KIRKLEES METROPOLITAN COUNCIL INVESTMENT & REGENERATION SERVICE

DELEGATED DECISION TO DETERMINE APPLICATIONS FOR LISTED BUILDING CONSENT

Reference No:	2023/65/91257/W
Site Address:	Reap Hirst House, Reap Hirst Road, Birkby, Huddersfield, HD2 2DD
Description:	Listed Building Consent for demolition of existing conservatory, and erection of single storey extension, new rear entrance canopy, replacement windows and door and reintroduction of mullions and chimney, minor external modification and internal modifications of modern partitions
Recommending Officer:	Tom Hunt

Officer Report

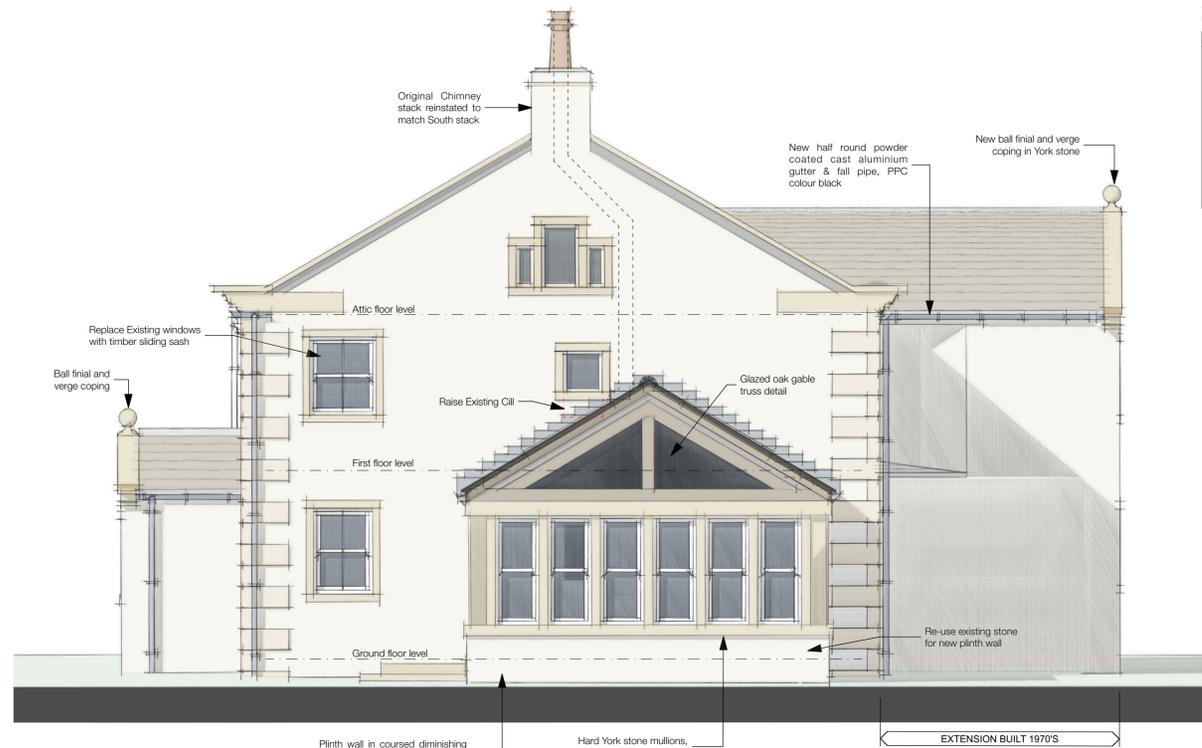
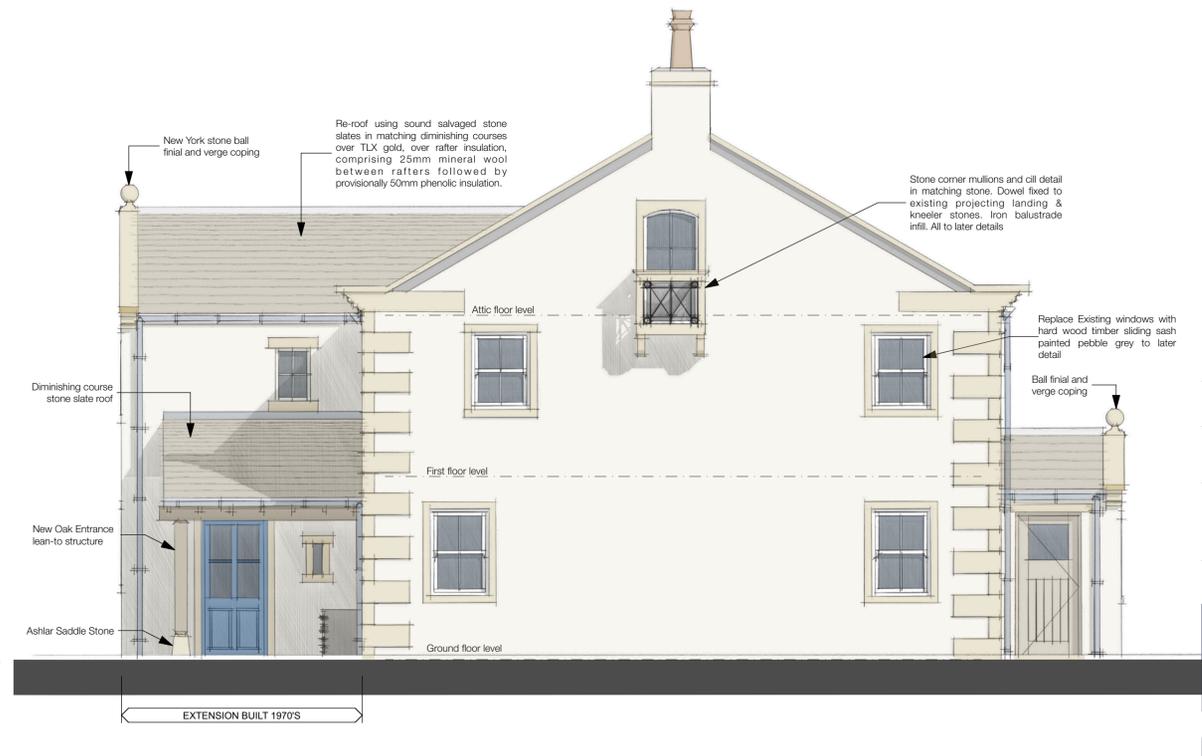
New windows are proposed on the southwest elevation at first floor level for the host and its two-storey rear projection. The proportions and configuration of the windows and surround closely match the existing, and the introduction of further natural light within the spaces as well as the benefits brought by other elements of the proposal is considered to outweigh the slight harm to significance of this element of the scheme.

Also on the south elevation is a large attic window with an external projecting ledge. This may have been an external door to the attic, although later rebuilding around the opening hides any evidence of the original detailing. The application proposes a small balustrade around the ledge and Officers consider this to be justified based on historic precedents supported by archival photographs. Officers recommend that final details of this design are to be conditioned to ensure the historic significance of the Building is adequately preserved.

Conservation roof lights are proposed on the rear roof pitch, providing natural light within the attic space without affecting the character of the prominent front pitch. They have been identified as set into the roof either side on the proposed extension and in slate grey finish in plans and subject to a condition ensuring that all rooflights be flush with the roof and suitably detailed, the historic significance of the Building can be adequately respected.

The proposed chimney stack on the north gable reinstates a missing historic feature and symmetry with the existing south gable chimney which would enhance the significance of the Listed Building.

3. New opening windows shall be hardwood timber double-glazed sliding sashes with cords, pulleys and weights. All slim double-glazed units shall have 4mm glass with a 12mm gap and warm black spacer bars. The pebble grey paint colour and finish shall be in linseed with matt finish. The works shall be carried out in complete accordance with the details approved by this condition and retained thereafter.

4. Notwithstanding the submitted plans and information, full details of the balustrade fixed to the projecting attic floor ledge on the south elevation (elevation drawings at 1:20 scale and section drawings at 1:5 scale), shall be submitted to and approved in writing by the Local Planning Authority prior to this work commencing on this element. All works to the balustrade fixed to the projecting attic floor ledge on the south elevation shall be carried out in complete accordance with the details approved by this condition which shall be thereafter retained.

5. The rooflights hereby approved shall be in conservation style, in slate grey finish and fitted flush to the roof plane. Glazing shall have a thickness of no more than 16mm at 4:8:4 ratio. Frames shall have black warm spacers. They shall not have trickle vents or make use of friction or egress hinges. Thereafter the rooflights shall be installed in accordance with the approved details and retained as such.
